# M25 junction 10/A3 Wisley interchange

### 9.59 Applicant's Response to the Royal Horticultural Society's Deadline 4 letter

<b>Regulation Number:</b>	8 (1)(c)(i)
<b>Planning Inspectorate Scheme Reference</b>	TR010030
<b>Application Document Reference</b>	TR010030/EXAM/9.59
<b>Author:</b>	M25 junction 10/A3 Wisley interchange project team, Highways England and Atkins

<b>Version</b>	<b>Date</b>	<b>Status of Version</b>
Rev 0	3 March 2020	Deadline 5

the Traffic, Transport & Highway Consultancy		Drawing No	M16114-C-012A	Rev	.
		Date	26.11.2019	Rev Date	.
		Drawn By	WHS	Authorised	MH
				Scale	NTS
REGIONAL INVESTMENT PROGRAMME M25 J10 IMPROVEMENT EXTRACT FROM DRAWING: HE551522 - ATK - HGN - A3B - DR - D - 0002

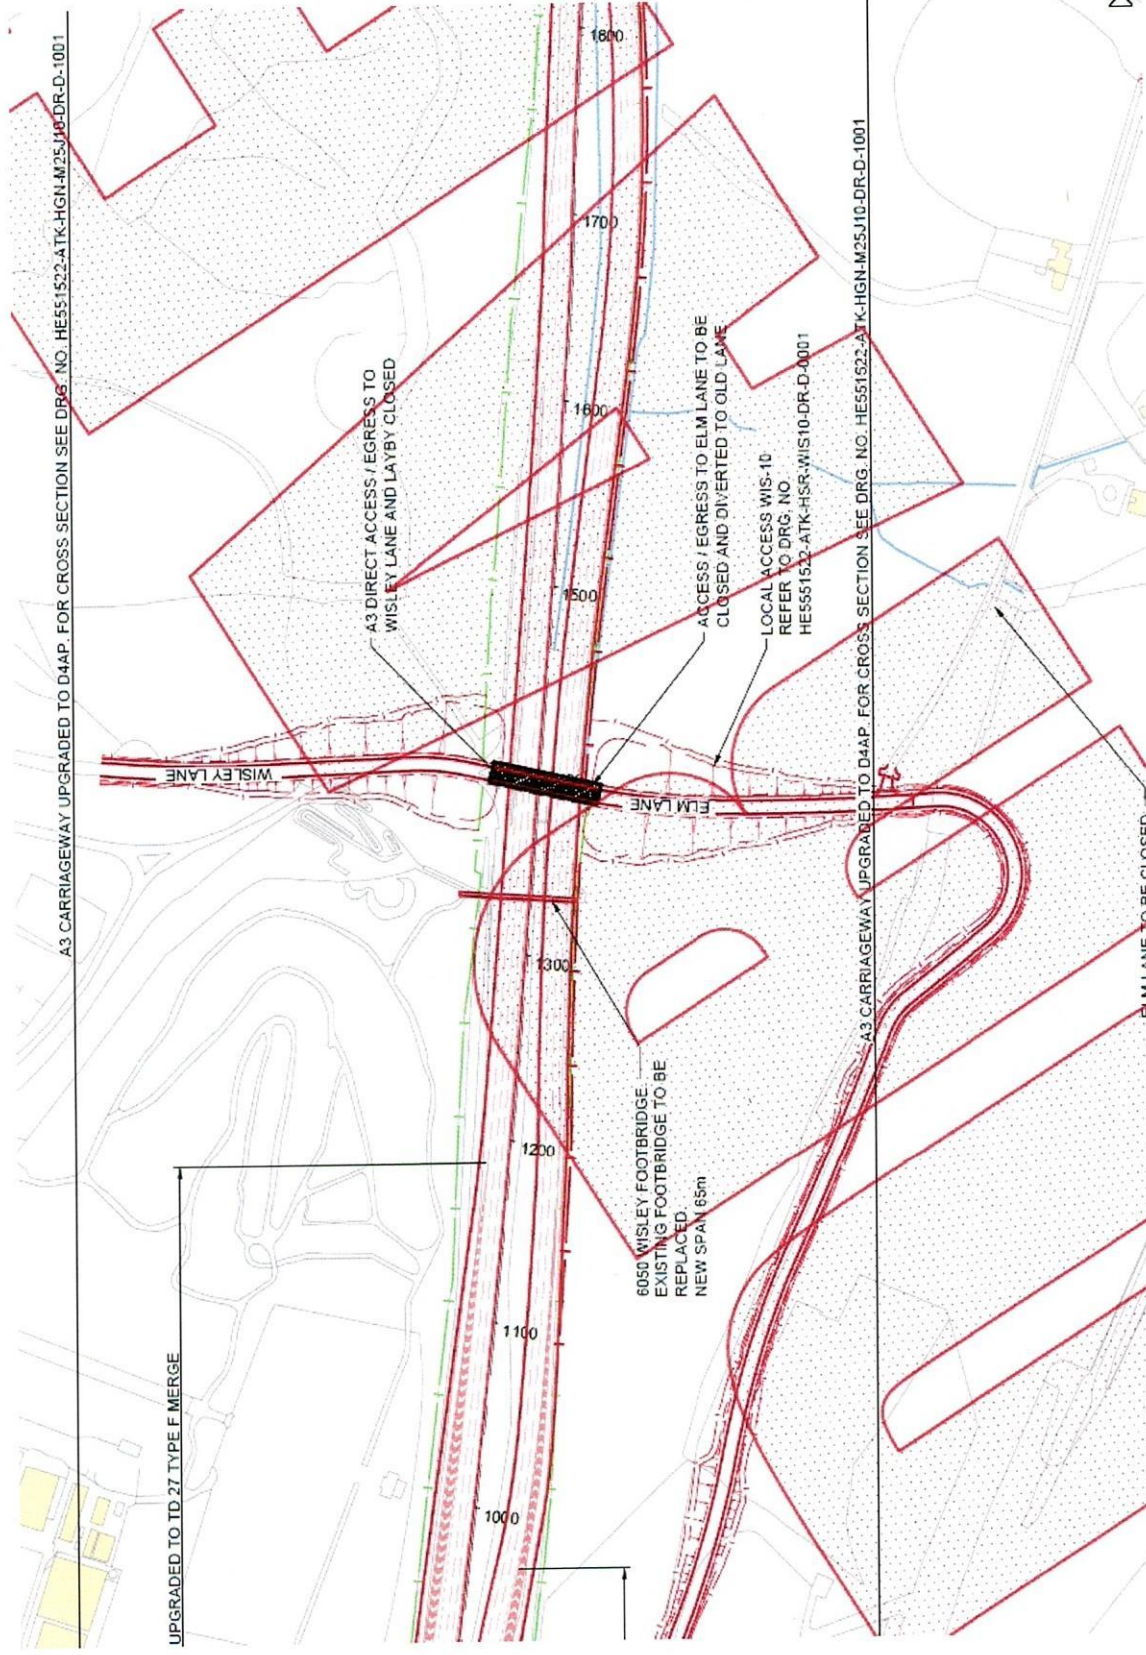
Reference	RHS's Comment	Highways England Response
19.	<p>This issue has not been progressed since Deadline 3. The RHS's longstanding and fundamental concerns remain; the fate of these Redwood Trees has now become unclear and the DCO Scheme may have to be altered. The RHS does not believe the proposed realignment will, in fact, protect the trees. As yet, no formal proposals to deal with the likely impacts on the tree roots and the realignment of the A3 have been put forward by HE.</p>	<p>This has been progressed – see Highways England's response to ExA Q2.8.1 in document TR010020/ Volume 9.58, also submitted at Deadline 5.</p>
<b>Conclusions</b>
